OXFORDSHIRE COUNTY COUNCIL'S RESPONSE TO CONSULTATION ON THE FOLLOWING DEVELOPMENT PROPOSAL

Application No: 14/01384/OUT-2

Location: Bicester Eco Town Exemplar Site Banbury Road B4100 Caversfield

Transport

BIMP6 110C Movement and Access

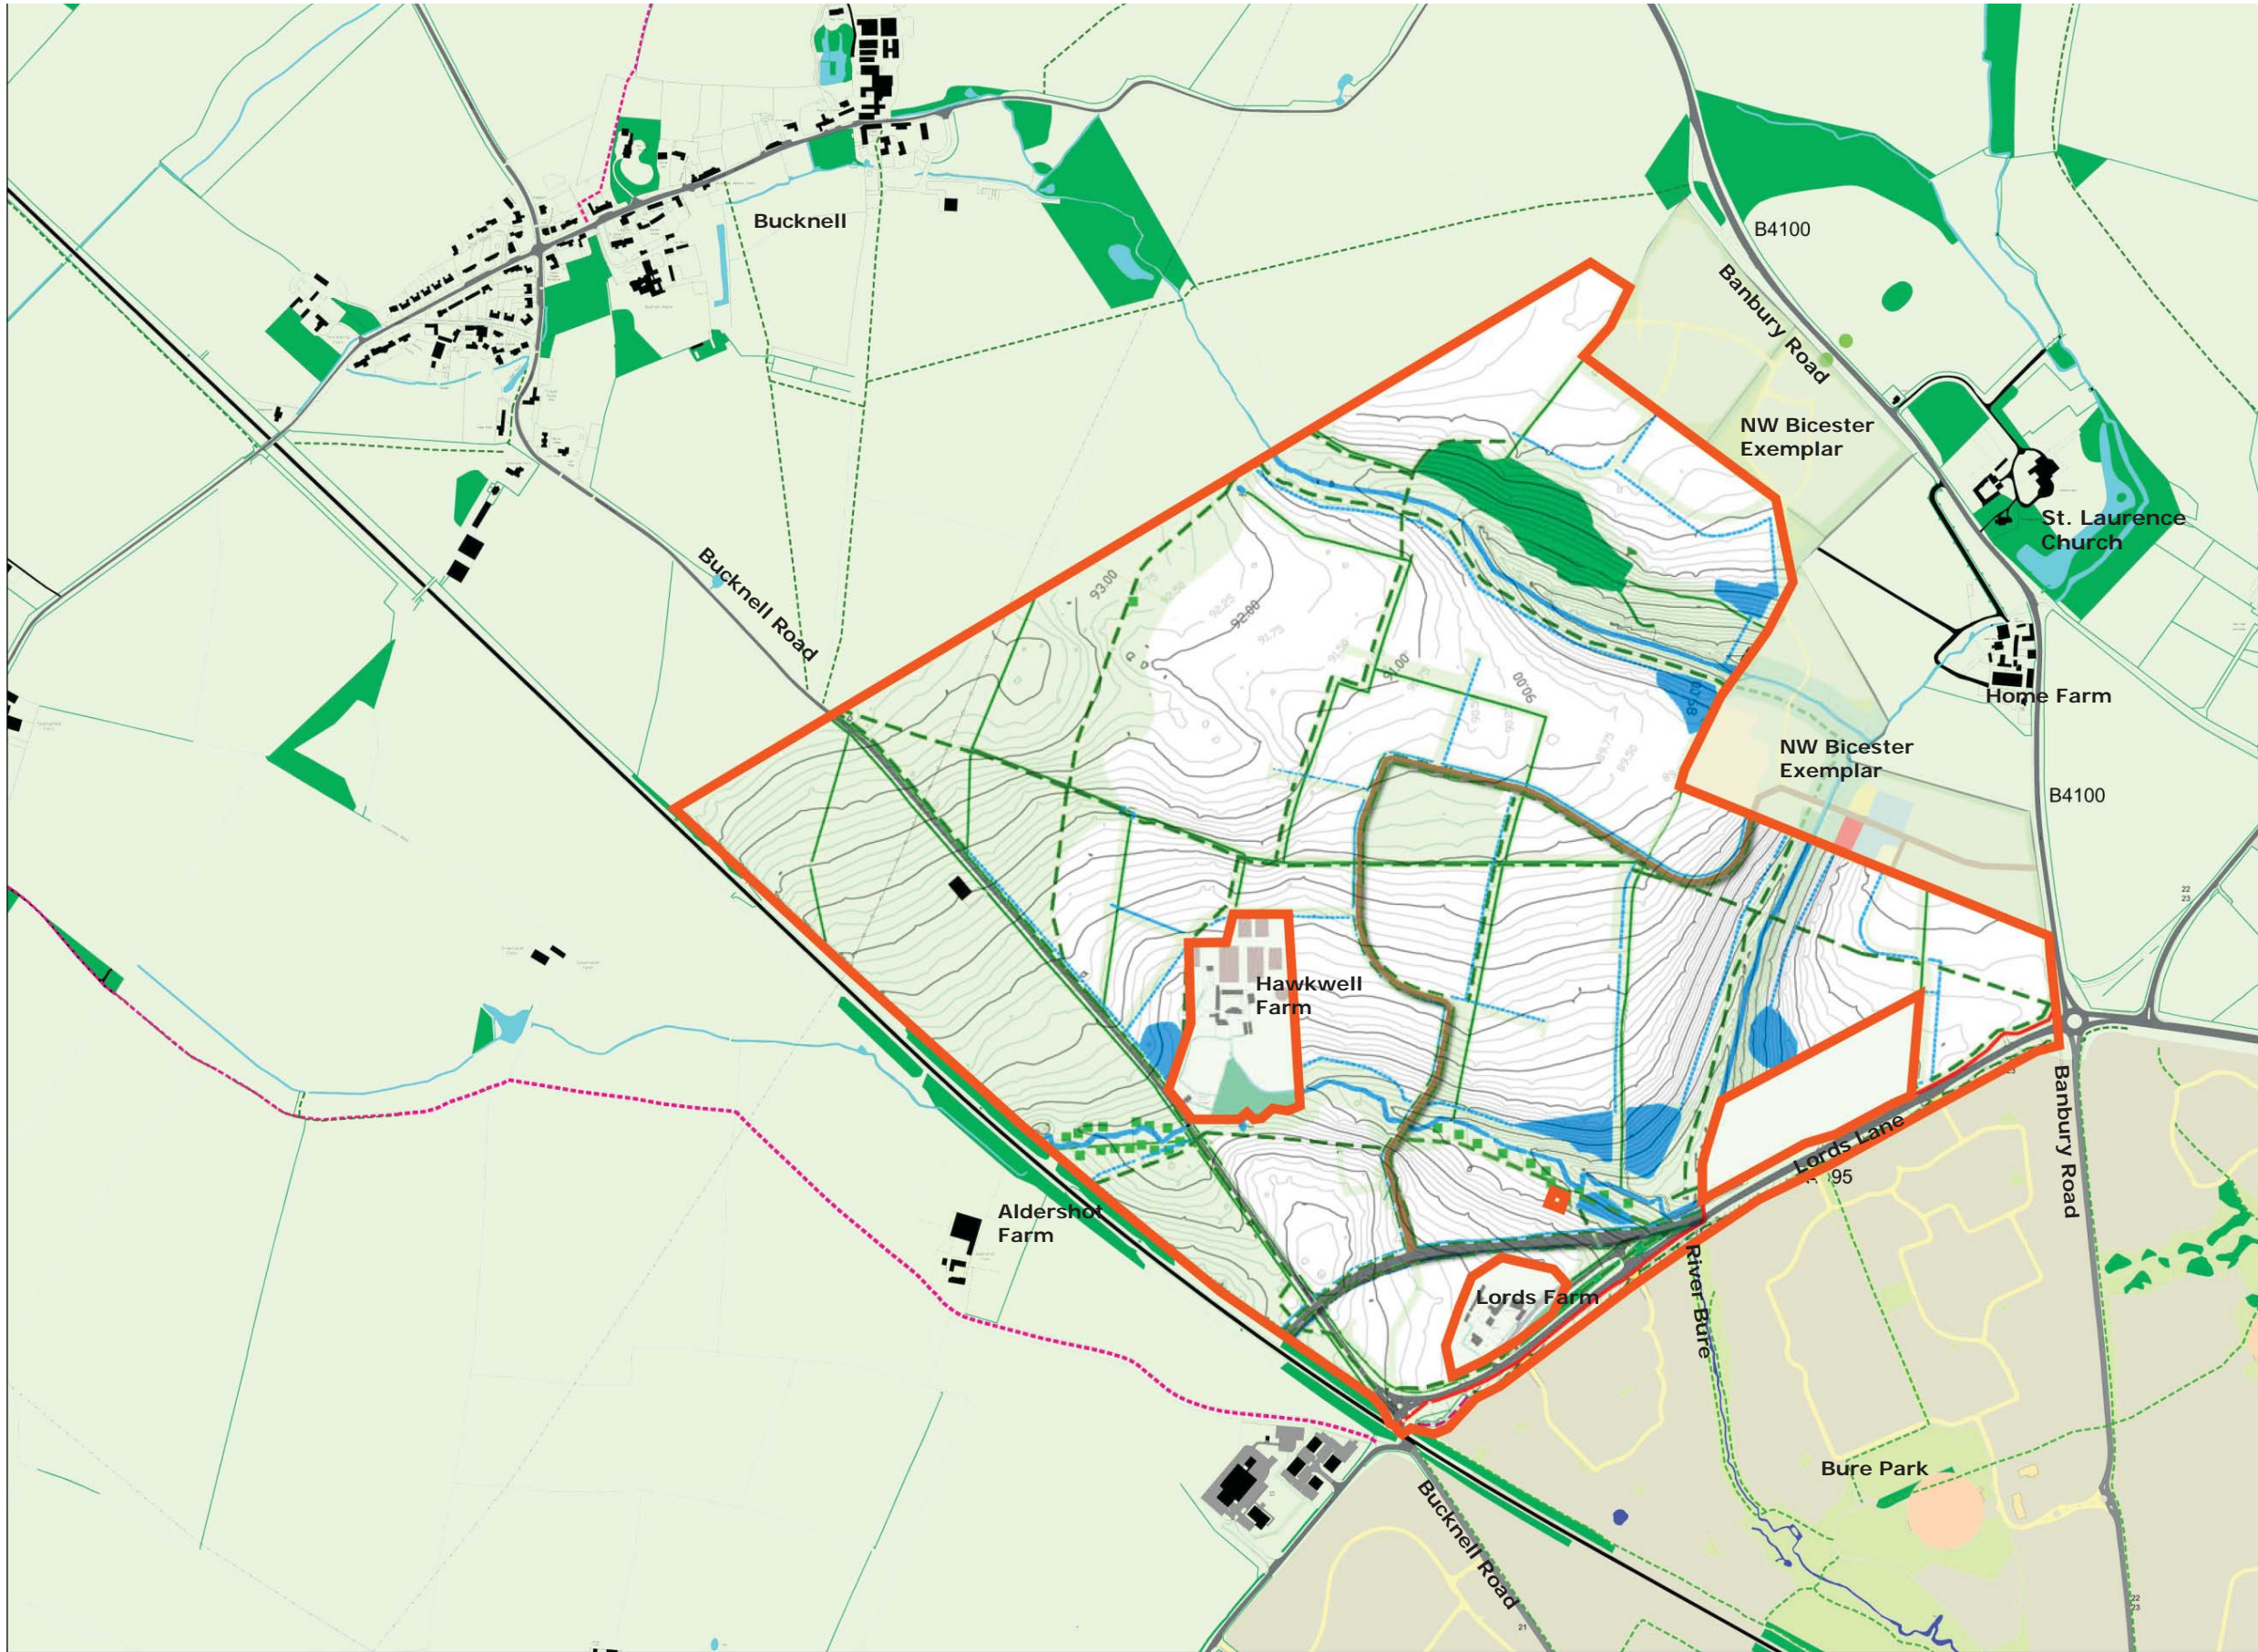
The Movement and Access parameter plan should show positions for the bus stops. At the village centre the stops need to be as close to the junction with the Strategic Link Road as possible: northbound on the NW corner, eastbound on the NE corner, southbound on the SE corner, and westbound on the SW corner. **Further detail required.**

Indicative stops should be shown for other stops in the bus loop, including any required on temporary bus loops. **Further detail required.**

Cycle/pedestrian routes: Additional proposed routes are welcomed. However, the dotted green line on the primary route between the sports pitch and the school playing field appears to have been removed.

Where the cycle link has been moved from the south to the north of the stream, it is difficult to see how this would reconnect with Lords Lane without a new stream crossing. **Further detail is required.**
